PLANNING CONSULTATION RESPONSE

Application No	2025/1062
Proposal	Demolition of existing domestic garage and formation of new driveway/parking, and outline permission for the erection of 4 houses within the residential garden (including access and layout details).
Address	Land adjacent to 1A West Street, Worsbrough Bridge, Barnsley, S70 5PG
Date of Consultation Reply	11/08/2026
Consultee	Katie Lawrence, Planning Ecologist

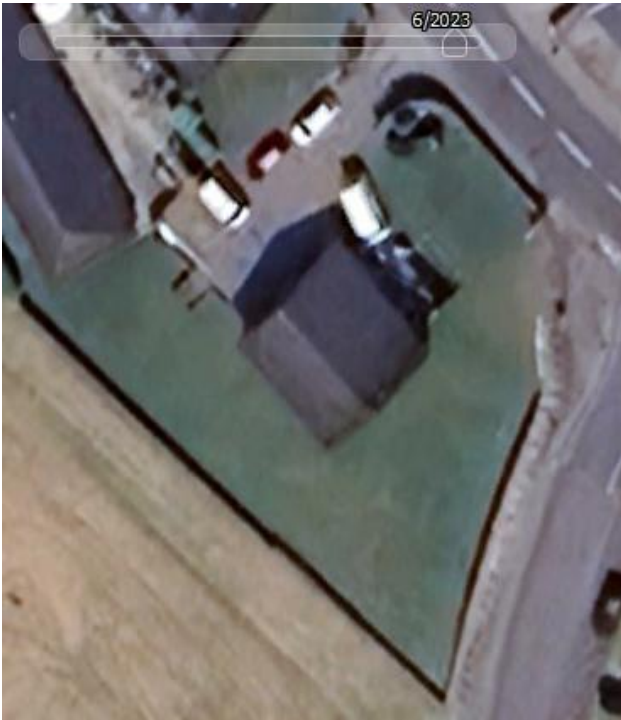
Thank you for providing updated Biodiversity Net Gain (BNG) information following the previous consultation response. The updated report and metric confirm that proposed habitats within the vicinity of the proposed dwellings are now vegetated garden. The metric indicates that this will result in a loss of 0.039 habitat units (-20.26%) although a gain in 0.0096 (19.98%) hedgerow units is able to be achieved. The BNG report sets out that consideration can be given to additional landscaping on site (this would need to take place on any areas of public open space) or the purchase of off-site units in order to meet the 10% BNG requirement. This can be set out when coming to discharge the Biodiversity Gain Condition.
